**re:     Geotechnical Review of Grading Plans**  
**Proposed Commercial Development**  
1015 & 1045 Dairy Drive – Ottawa, Ontario

**date:   July 2, 2025**

**file:   PG6498-MEMO.03**

GRADING PLAN

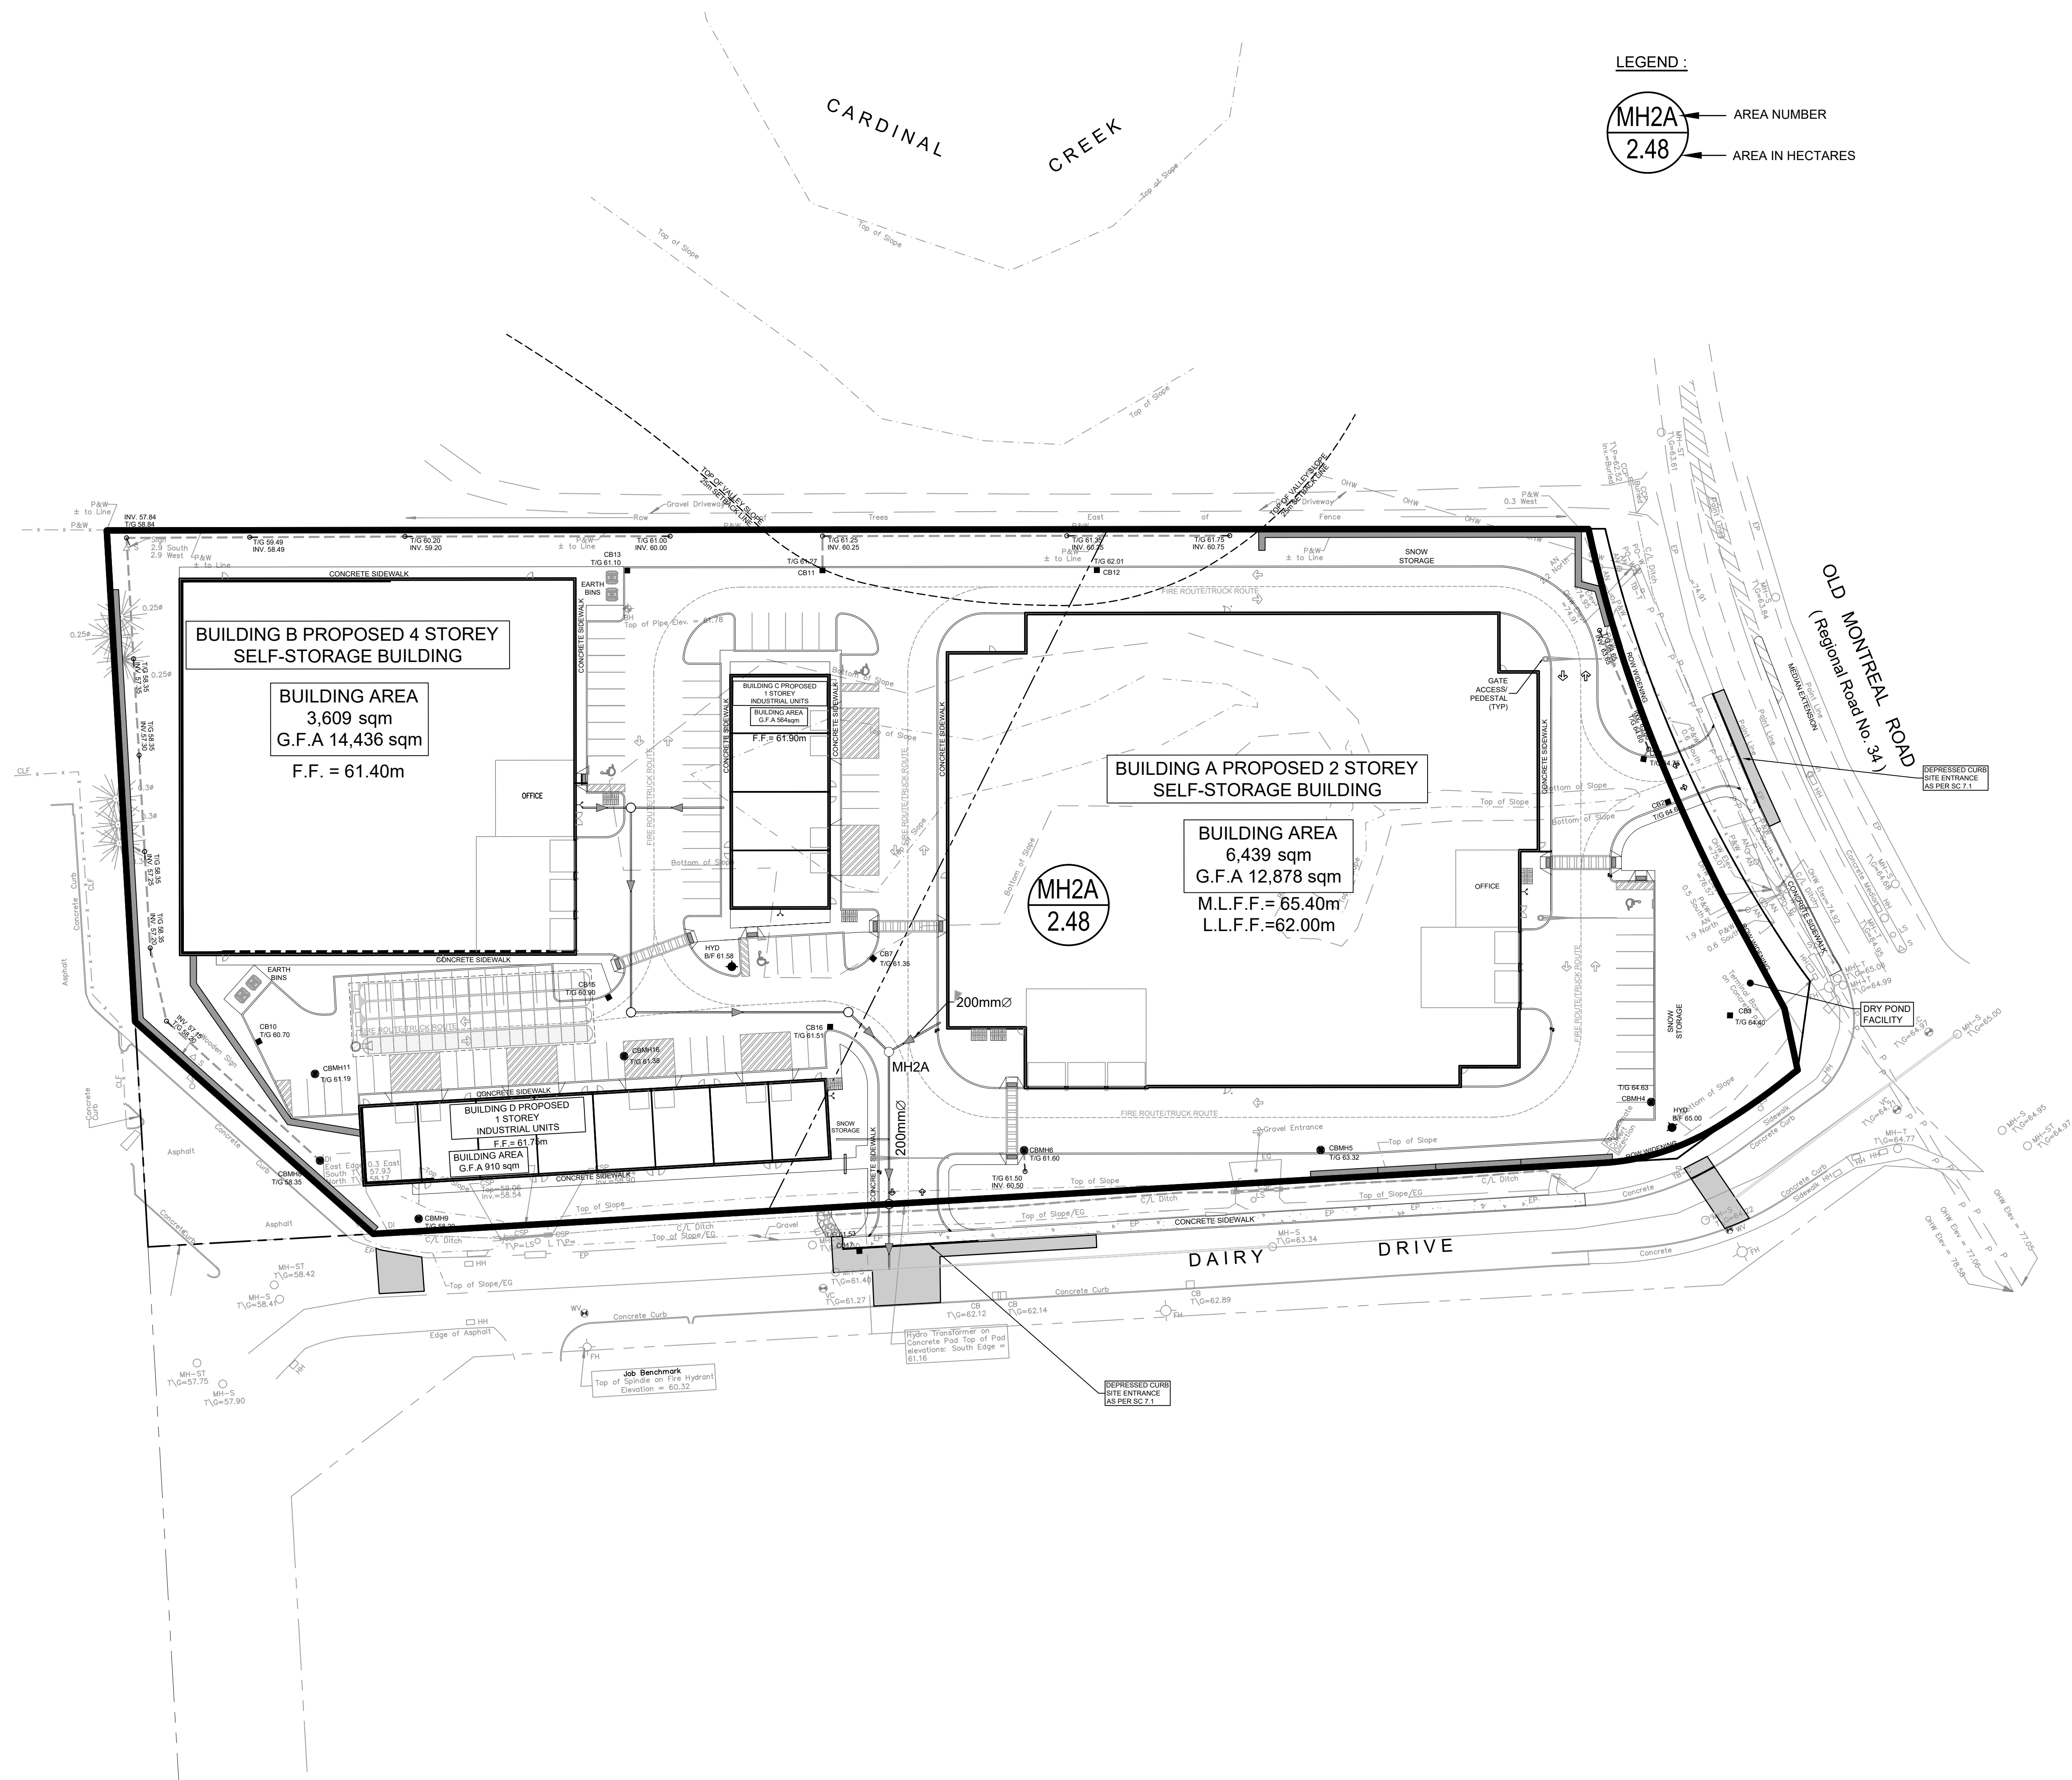
Due to the presence of a silty clay deposit at this site, the proposed development will be subjected to grade raise restrictions based on the shear strength and consistency of the underlying silty clay deposit.

In reviewing the Grading Plans, the proposed grading for the subject site is generally within the permissible grade raise recommendations provided in the Geotechnical Investigation Report, referenced above. However, where localized grade raise exceedances have occurred, lightweight fill, such as expanded polystyrene (EPS) geofoam blocks, is recommended for specific areas adjacent to the subject commercial buildings.

The attached Drawing PG6498-7 depicts the locations and the thickness of the lightweight fill (LWF) required based on our grading plan review, and the attached Figure 1 provides a general detail for LWF placement. The EPS blocks should be placed on a level, well-prepared subgrade, with a geotextile separation layer to prevent soil intrusion and to promote drainage. The EPS blocks should be installed in a staggered, interlocking pattern and should be protected with a granular cover layer. The LWF placement should be conducted under the supervision of a geotechnical engineer.
